Addendum 01

Date: September 23, 2011

Regarding: **Elm Terrace** – Portland, Maine

Subject: **Addendum 01**

LIGHTING FIXTURE SCHEDULE

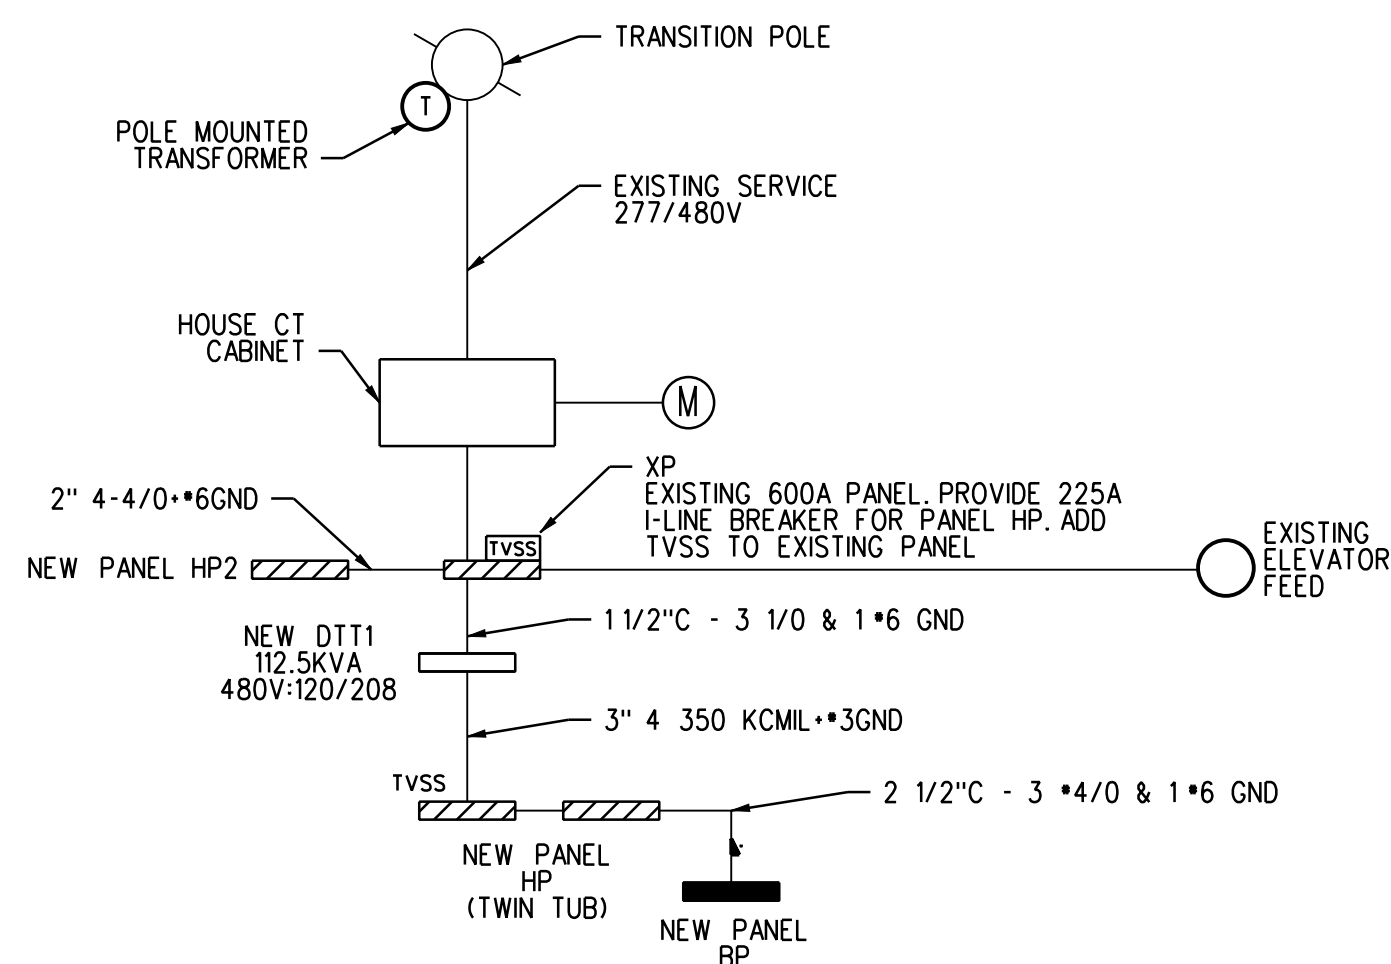
27. Drawing E4.0 – Schedules, One line and Symbols - CHANGE Lighting Fixture Schedule
Lighting Fixture Schedule: Change the following lighting fixture types to those listed:
 - a) Change Type C to read: Seagull #79661BLE-782 with lamps
 - b) Change Type F to read: Seagull #79435BLE-782 with lamps
 - c) Change Type G to read: Seagull #44062-782 with lamps
 - d) Change Type J to read: Seagull #69459BLE-782 with lamps

ONE LINE DIAGRAM - HOUSE LOADS

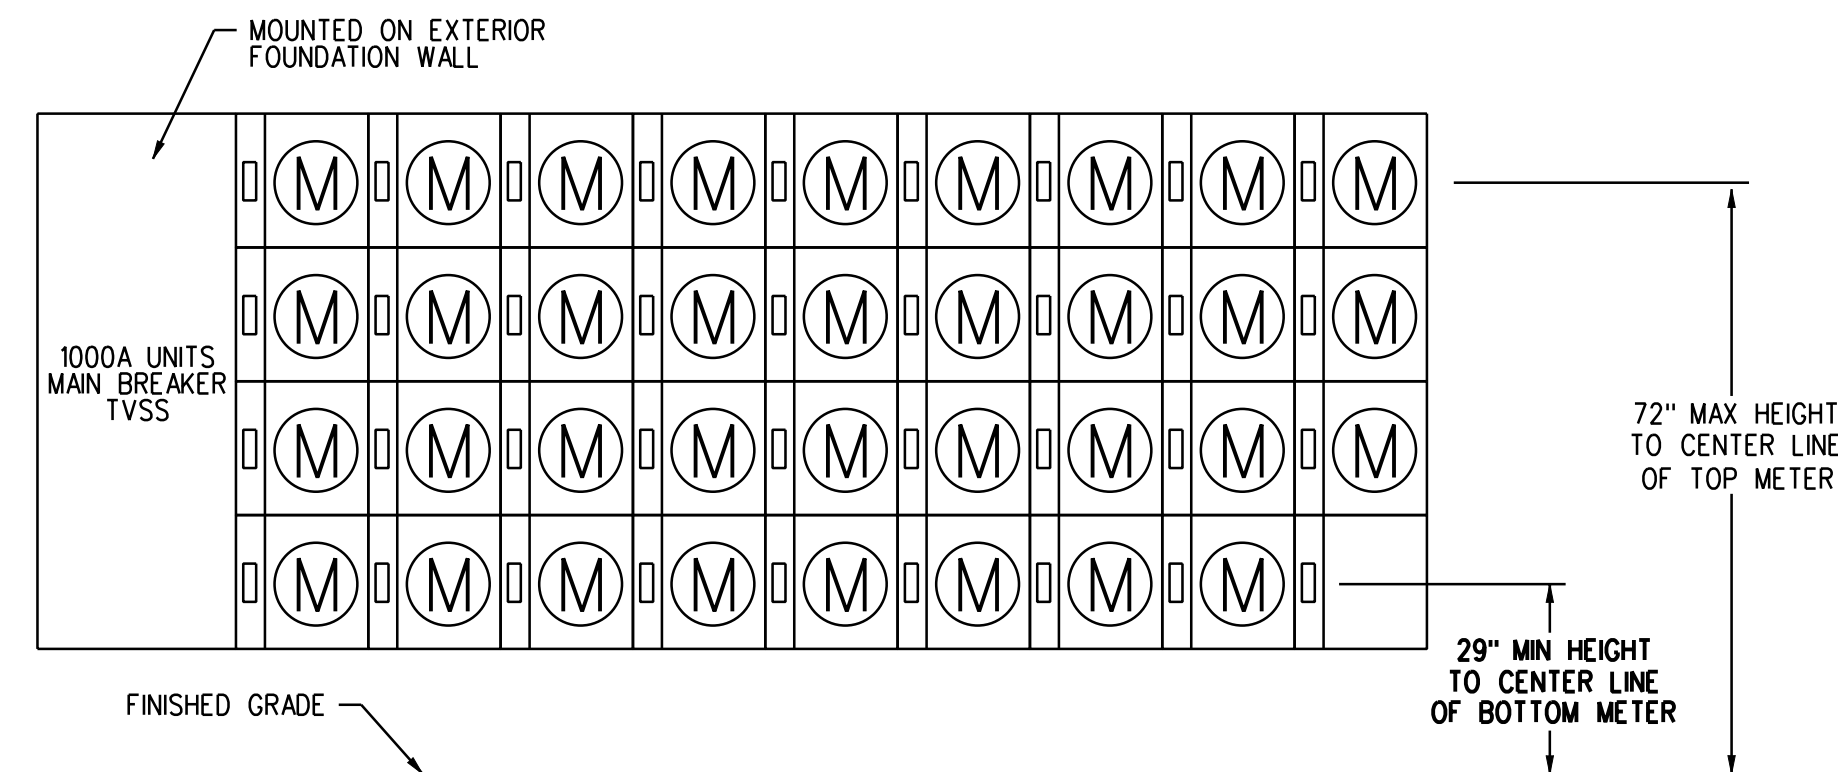
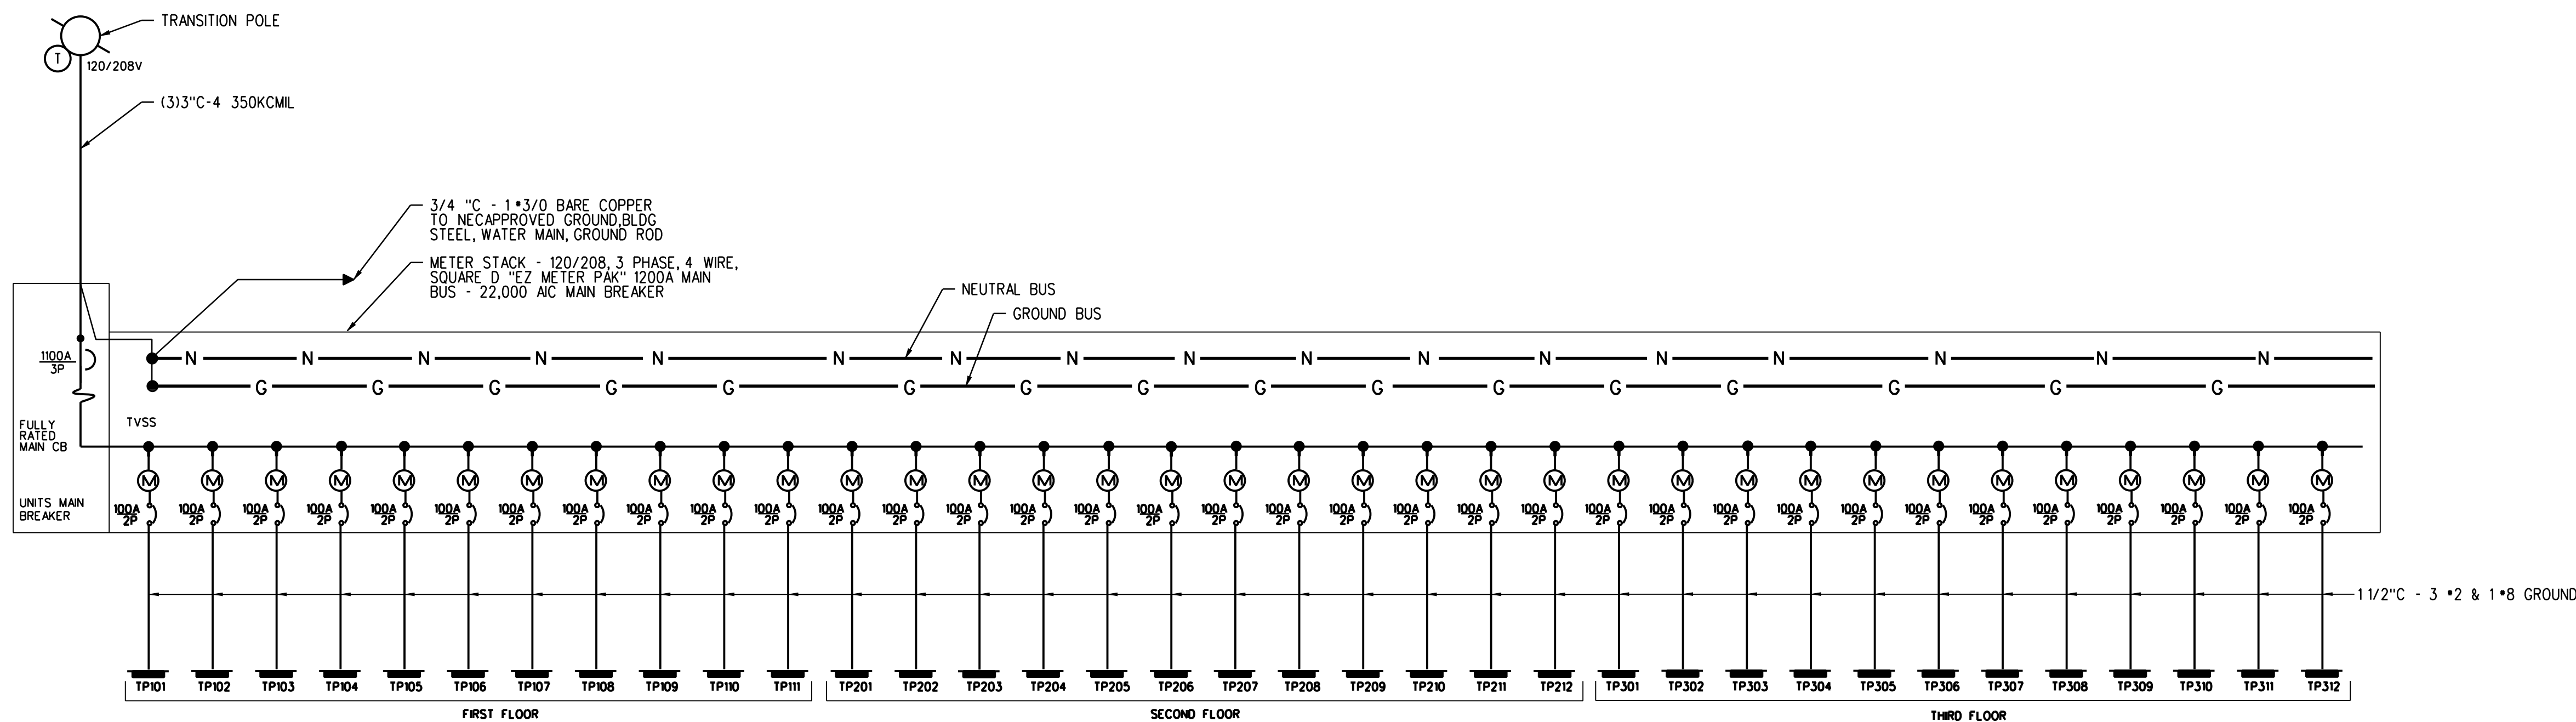
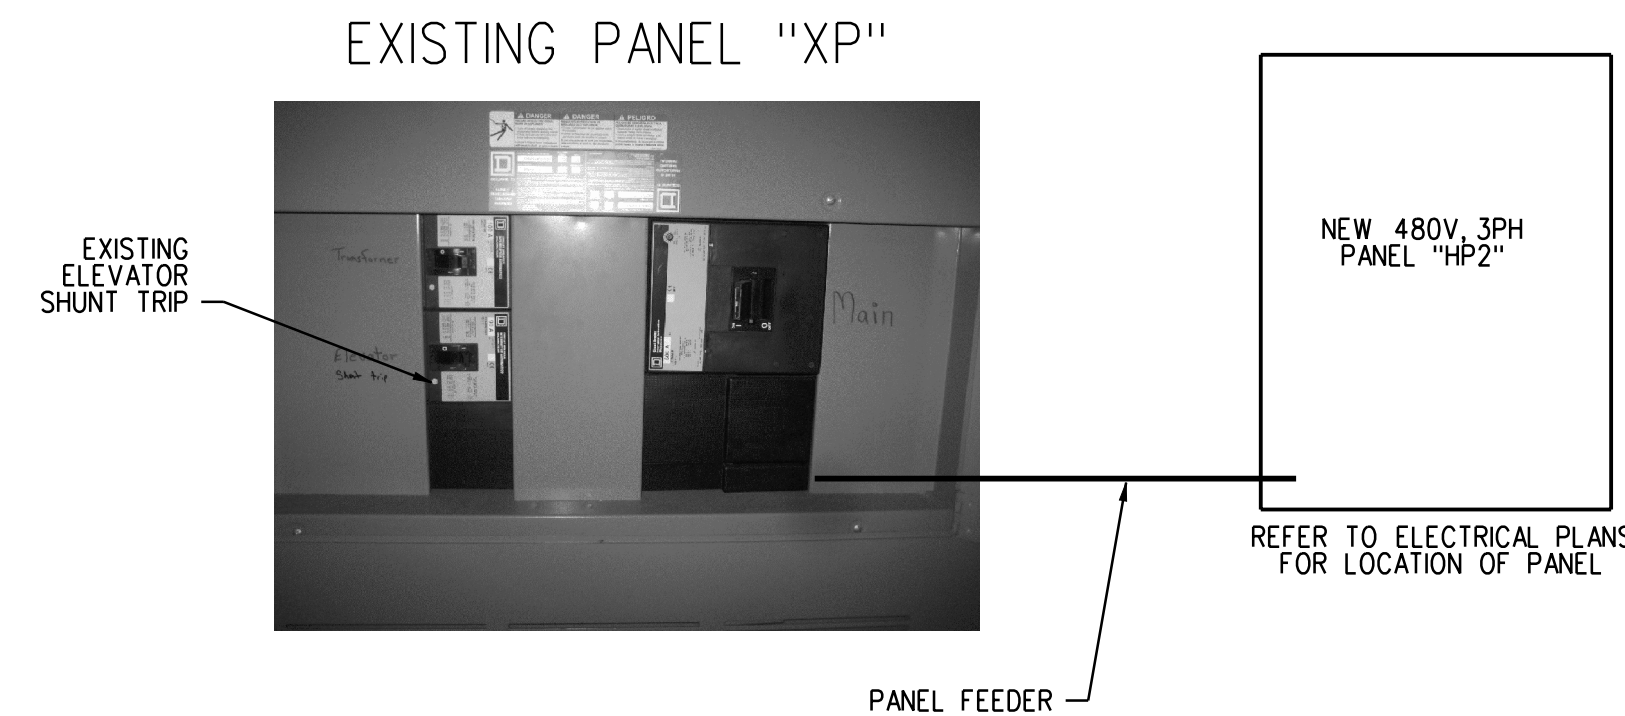
28. Review and incorporate the following RFI responses into the Scope of Work as indicated:
 - a) QUESTION: Please verify I-Line breaker size that feeds panel HP in existing panel XP on drawing E4.0. One note shows 225A and another note shows 135A? ANSWER: **Clarification: Need to install qty (2) breakers: (1) 135A, 3P breaker as noted for DTT1 which feeds panel HP and (1) 225A, 3P to feed panel HP2.**
